CITY OF ALBUQUERQUE

October 20, 2021

Re: KABQ CARGO FACILITY
2200 Sunport Blvd SE
Traffic Circulation Layout
Engineer's Stamp 10-18-2021 (P15-D004)

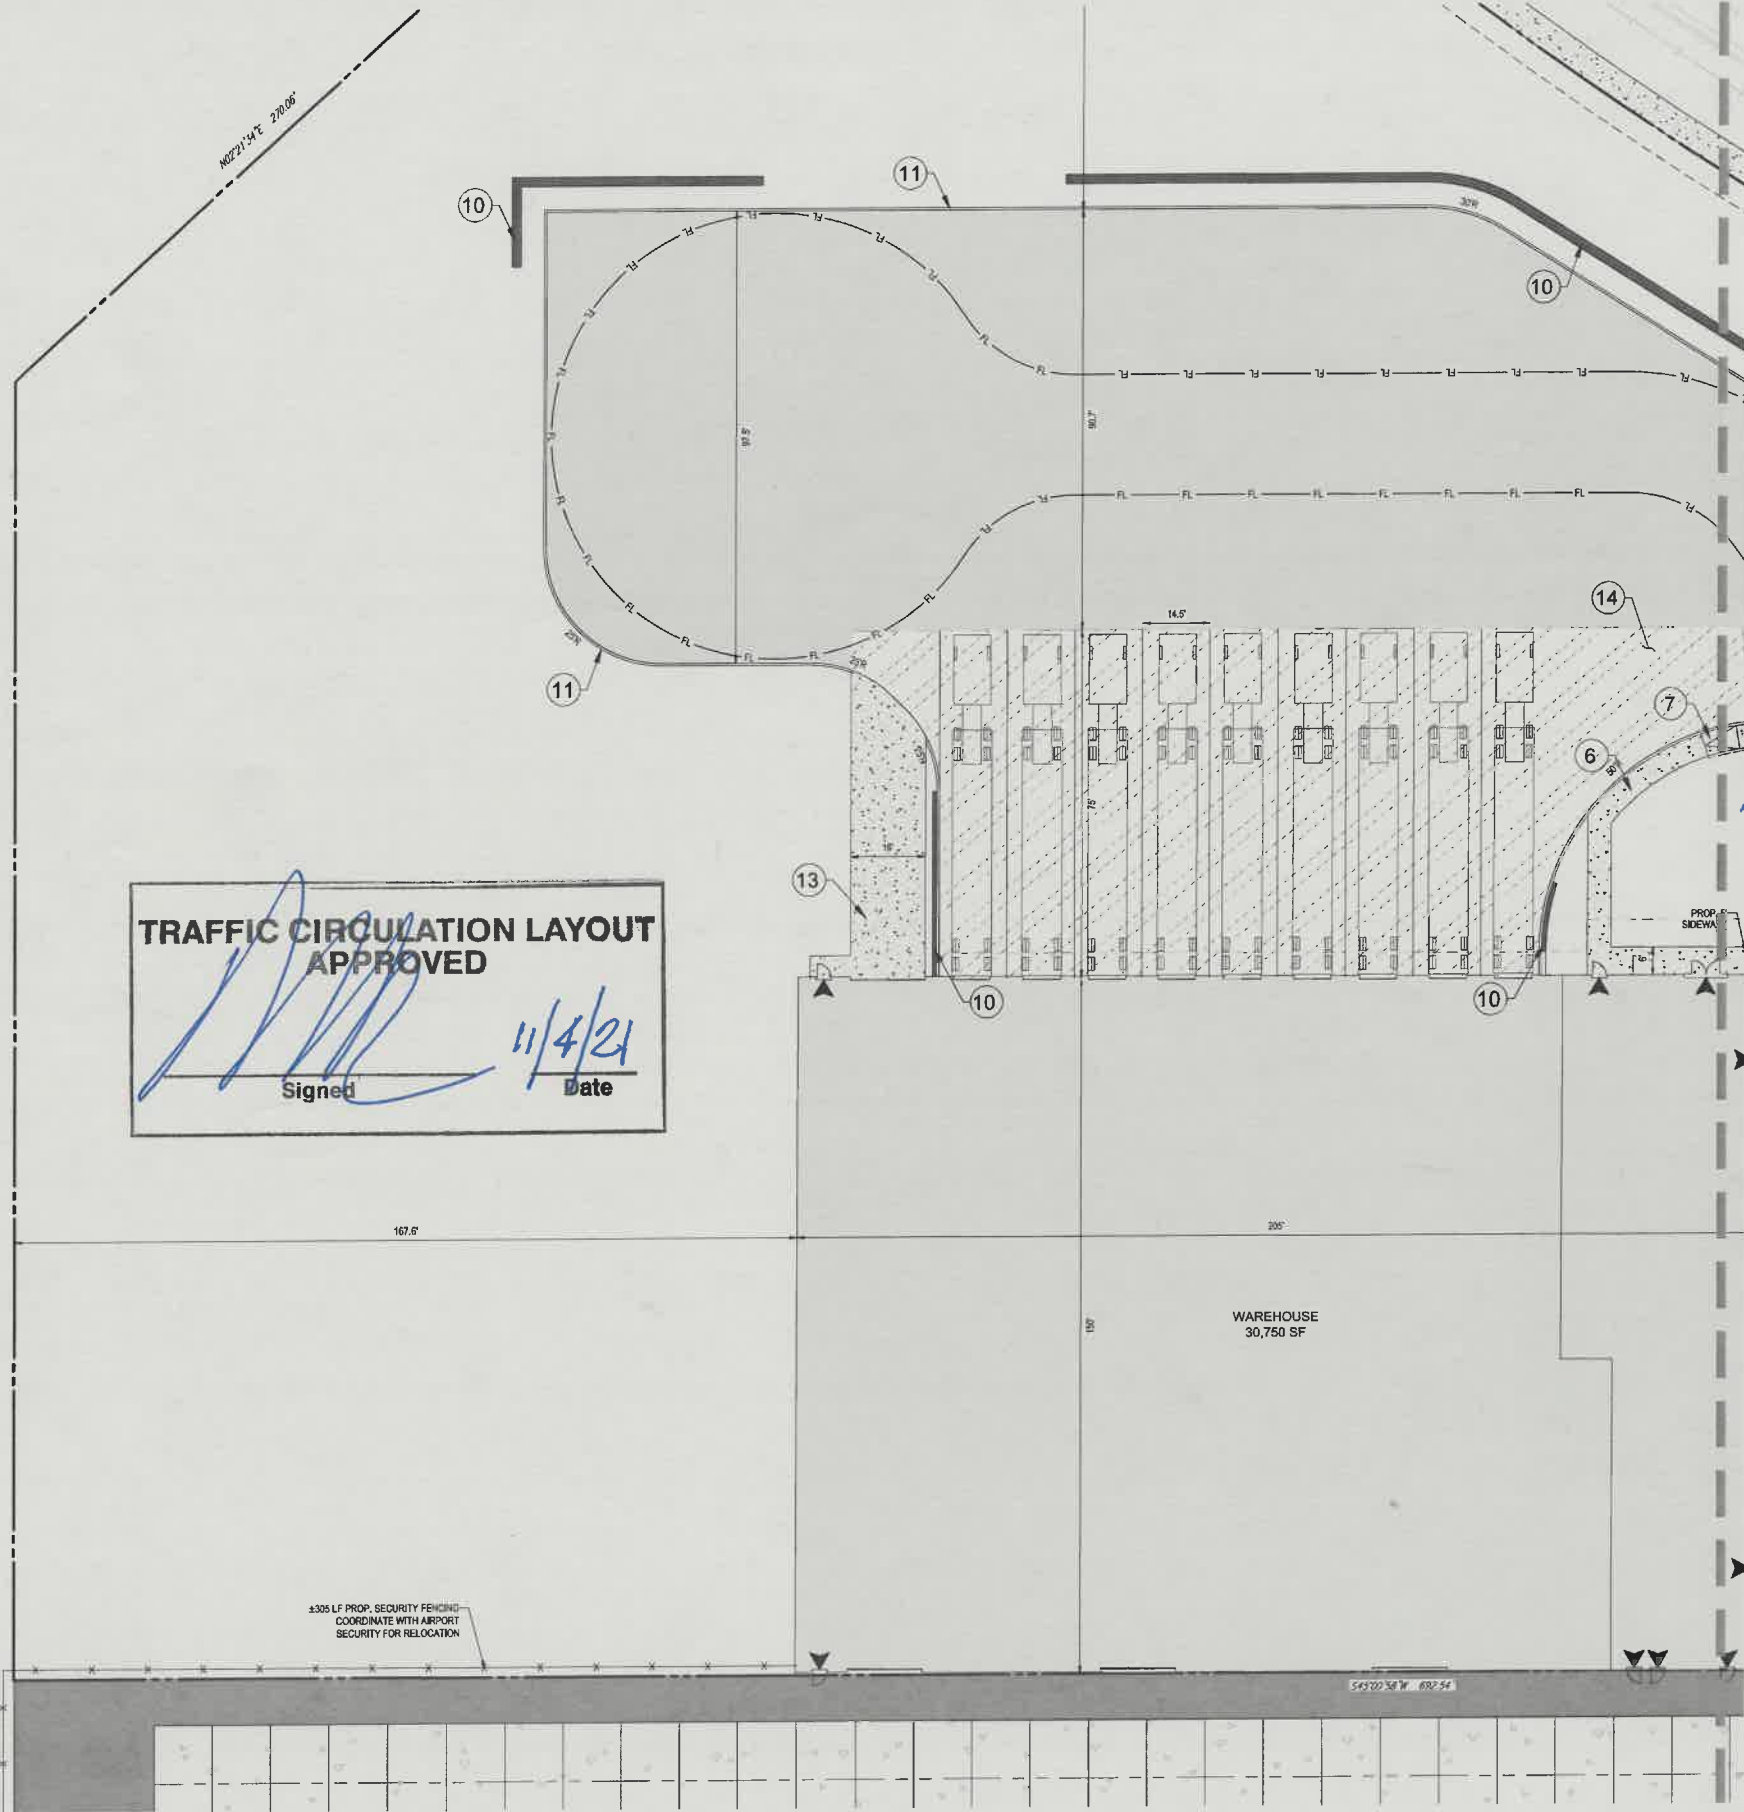
1. Listed are the number of parking spaces required by the IDO as well as the proposed number of parking spaces including bicycle and motorcycle parking.
Coordinate/discuss with Zoning.

2. **Spirit Drive frontage:**
 - What is the status of driveway connection onto Spirit Drive? Existing? Proposed?
 - Sidewalk status around the parameter off proposed development? Sidewalk is required on Spirit Drive frontage as well as ADA ramp.

3. Driveway design will be needed off access road onto site. This shall include sidewalk, ramps, curbing, valley gutter. **Provide construction notes to define this driveway entrance design.**

4. Provide a separate exhibit demonstrating turning movements on/off Spirit, access road and driveway entrance.
5. **Details and Construction notes:**
 - will be required on this Site Plan for all proposed Parking lot infrastructure, pavements markings, striping etc...

- Signage and sign face details
6. A scale of 1"=20' is recommended for sites less than 5 acres.
7. Identify the right of way width, street widths on Spirit Drive and Access road.

PO Box 1293

10. The ADA accessible parking sign must have the required language per 66-7-352.4C NMSA 1978 **"Violators Are Subject to a Fine and/or Towing."** Please call out detail and location of signs.

11. The ADA access aisles shall have the words **"NO PARKING"** in capital letters, each of which shall be at least one foot high and at least two inches wide, placed at the rear of the parking space so as to be close to where an adjacent vehicle's rear tire would be placed. (66-1-4.1.B NMSA 1978)

12. ADA curb ramps must be updated to current standards and have truncated domes installed. **Details will need to be provided.**
13. Motorcycle parking spaces shall be designated by its own conspicuously posted upright sign, either free-standing or wall mounted per the zoning code. Label pavement MC.

16. A 1-foot clear zone around the bicycle parking stall shall be provided.
17. Bicycle parking spaces shall be at least 6 feet long and 2 feet wide.
18. Per the IDO, a 6 ft. wide ADA accessible pedestrian pathway is required from the public sidewalk to the building entrances. Please clearly show this pathway and provide details.

19. Per DPM, a 6 ft. wide ADA accessible pedestrian pathway is required from the ADA parking stall access aisles to the building entrances. Please clearly show this pathway and provide details.

20. ADA accessible pedestrian pathway should not be placed behind parking space or adjacent to a vehicular way. Vehicle and pedestrian/wheel chair conflicts should be avoided as much as possible.

26. It is not apparent what type of pavement surface is being proposed. A hard driving surface will be required as part of this proposed project for parking area and drive aisles.

27. Please provide a sight distance exhibit
28. Show the clear sight triangle and add the following note to the plan: "Landscaping and signage will not interfere with clear sight requirements. Therefore, signs, walls, trees, and shrubbery between 3 and 8 feet tall (as measured from the gutter pan) will not be acceptable in the clear sight triangle.
